CITY OF PORTLAND, MAINE
Department of Building Inspection

Certificate of Occupancy

LOCATION 43 Shepherd Lane (Lot #28) 351-B-004

SUBJECT: Temporary Certificate of Occupancy for 43 Shepherd Lane

SITE PLAN FOR:
LOT 28 ORCHARD GREEN
SHEPHERD LANE, PORTLAND, ME.
OWNER / APPLICANT:
KASPRZAK, INC.
ROUTE 5, N. WATERBURY, ME.

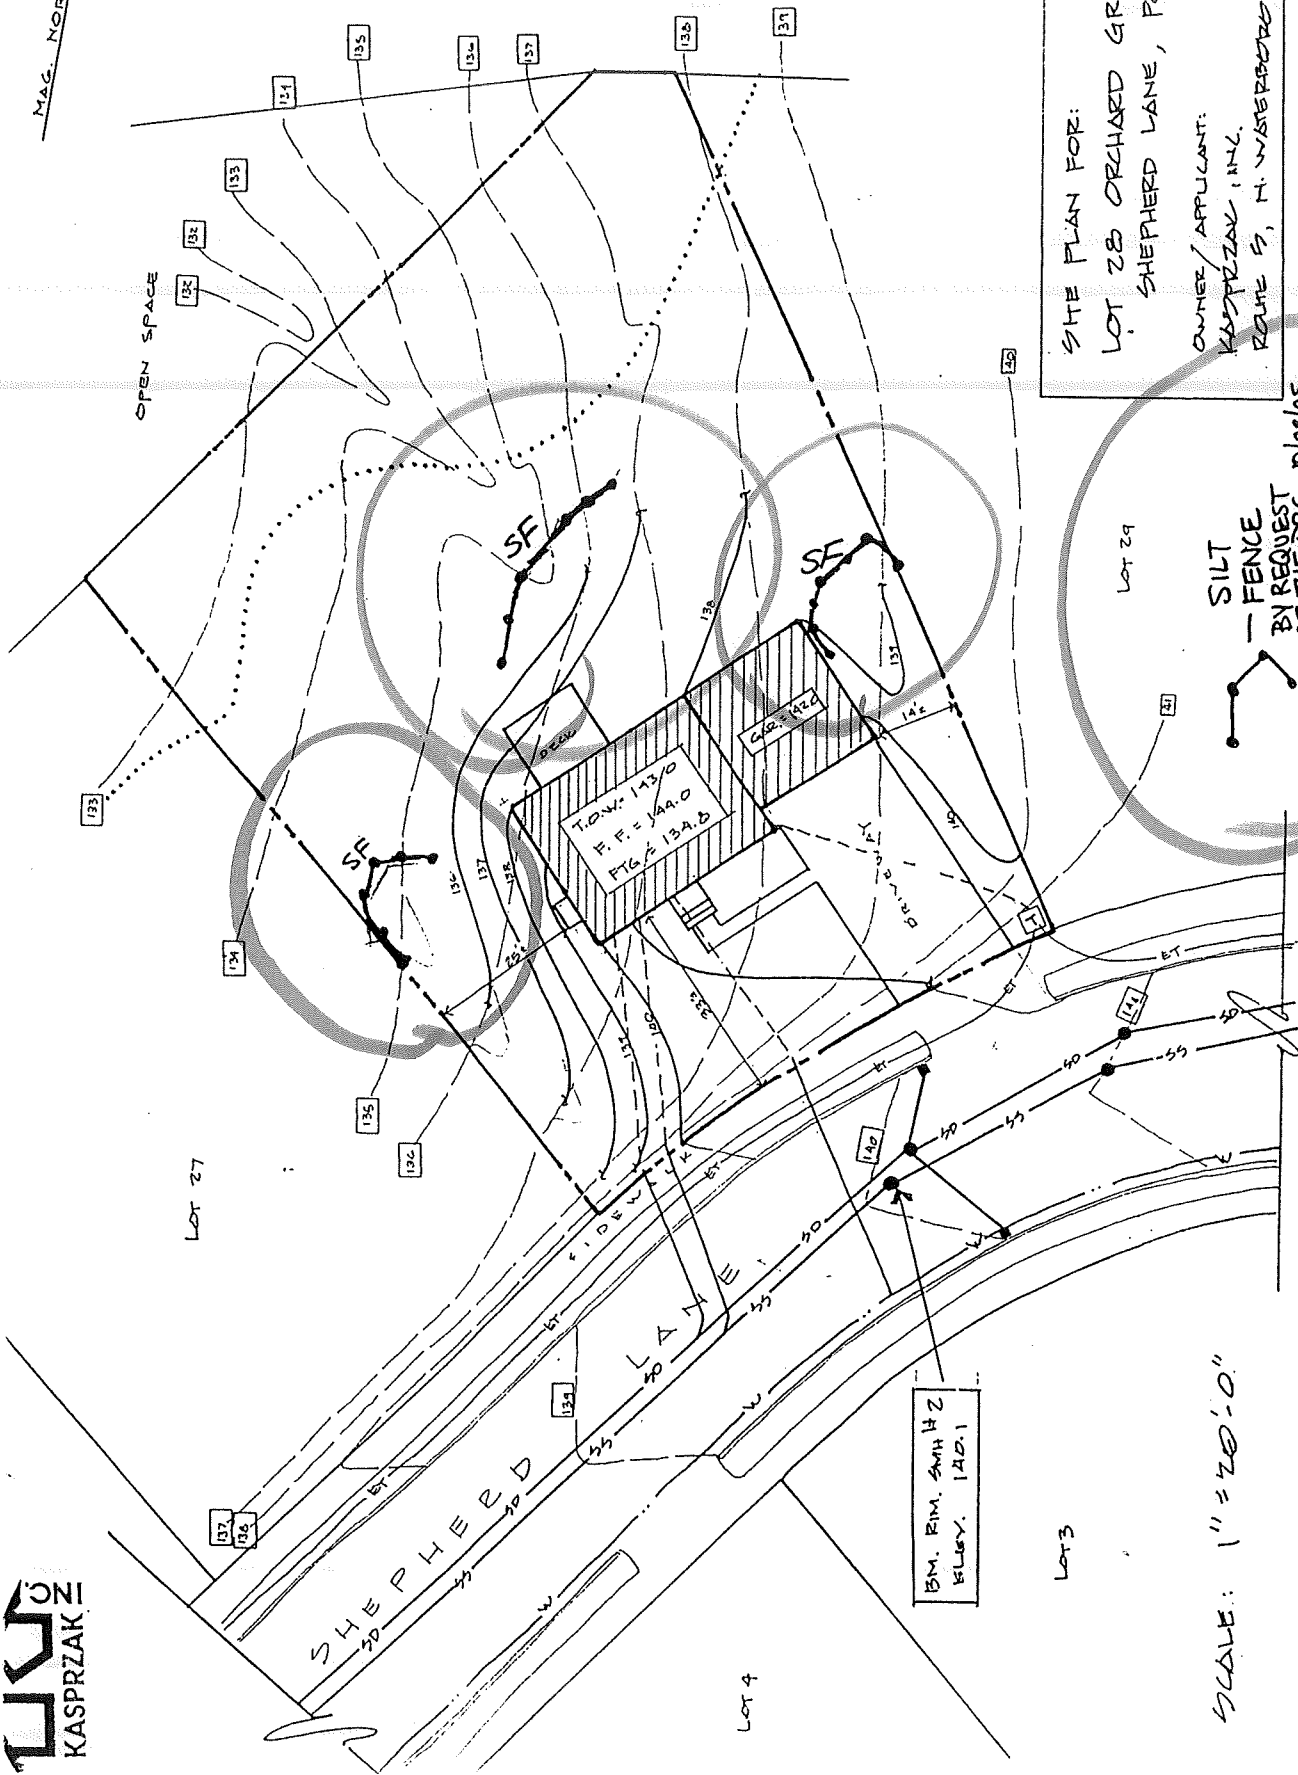
3. Silt fencing shall be installed as soon as weather permits, or before April 1, 1996 whichever occurs first. Silt fence shall be installed in accordance with the condition placed on the Building Permit Application dated 10/23/95. (Note 13 on the conditions sheet for the Site Plan Review.)
